MP 09_0212
RDC 08M1094 vol 3 –
SYD 09/00369/1
Sevda Huseyin
8849 2914

Transport
Roads & Traffic
Authority

**EXHIBITION OF PROJECT APPLICATION FOR BROADWAY BUILDING, UNIVERSITY OF
TECHNOLOGY SYDNEY (UTS) BROADWAY (MP09_0212)**

UTS BROADWAY BUILDING
SYDNEY
LEVEL B3 BASEMENT FLOOR PLAN
7352_CBT185AK-00117.J

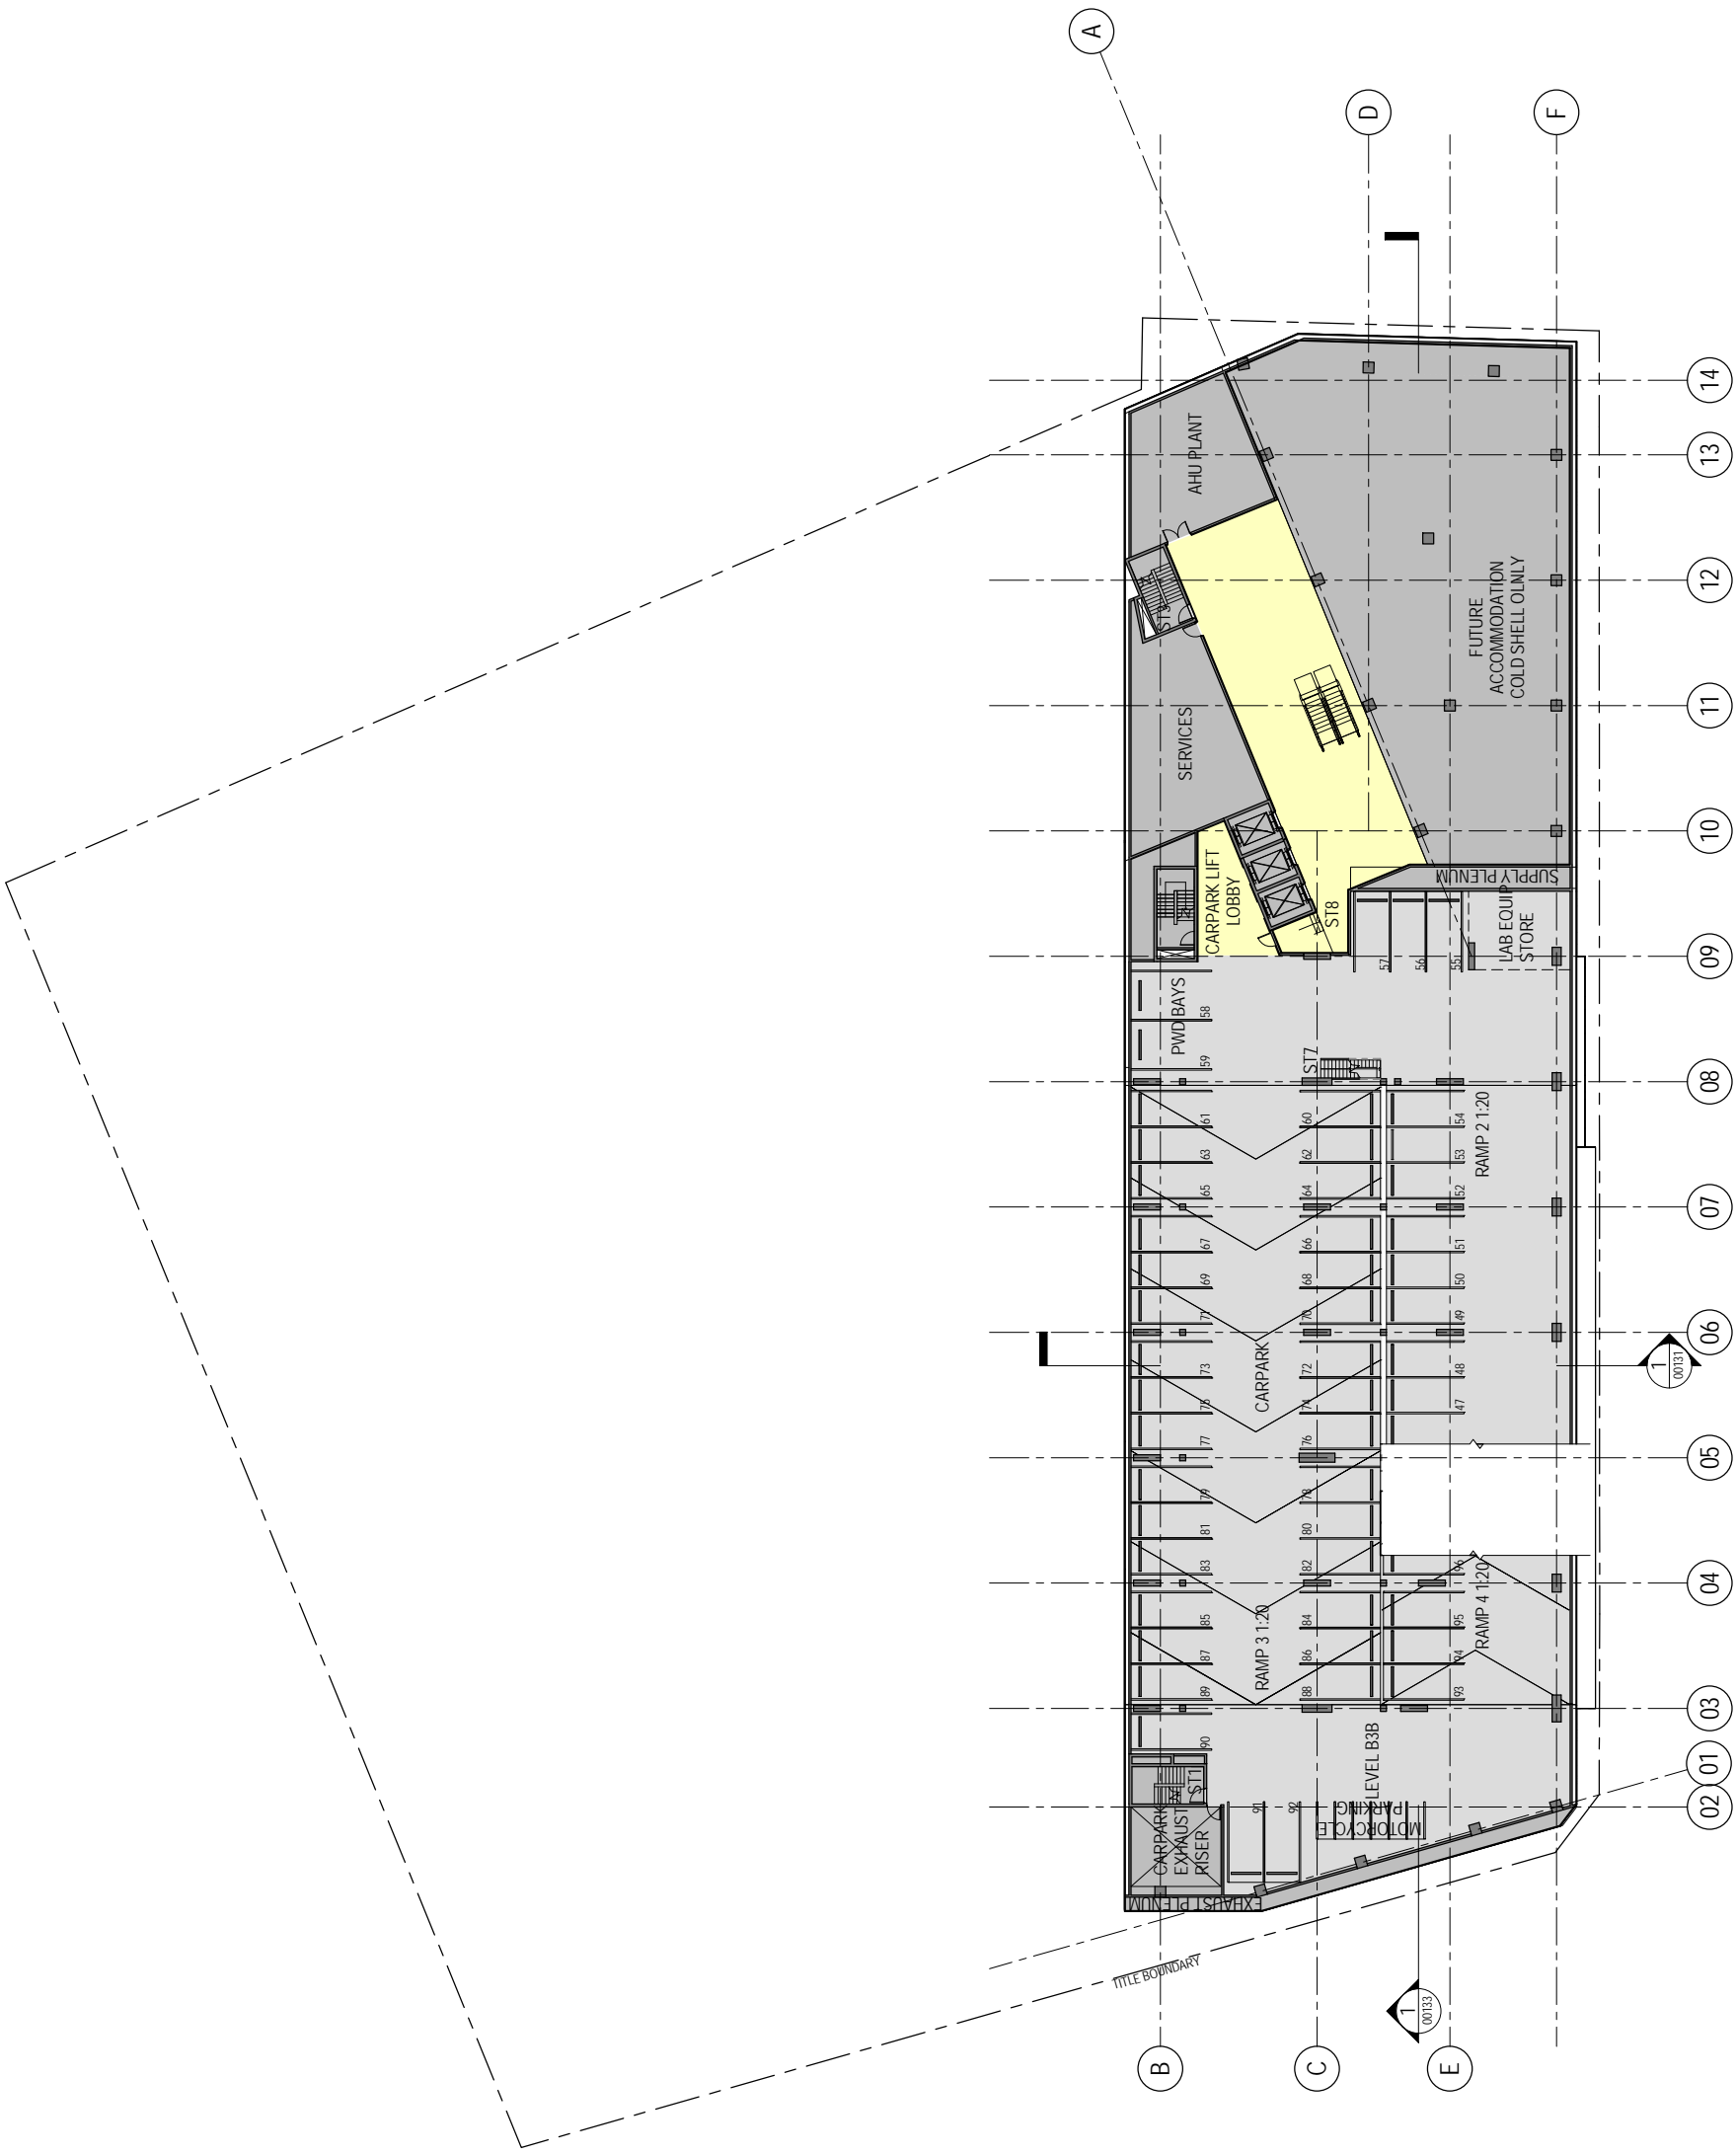
In this regard, the minimum queuing length between the boom gates and the property boundary shall be a minimum of three (3) car lengths per lane for two (2) entry lanes.

The internal aisle ways are to be marked with pavement arrows to direct traffic movements in / out of the site and guide traffic circulation through the car park.
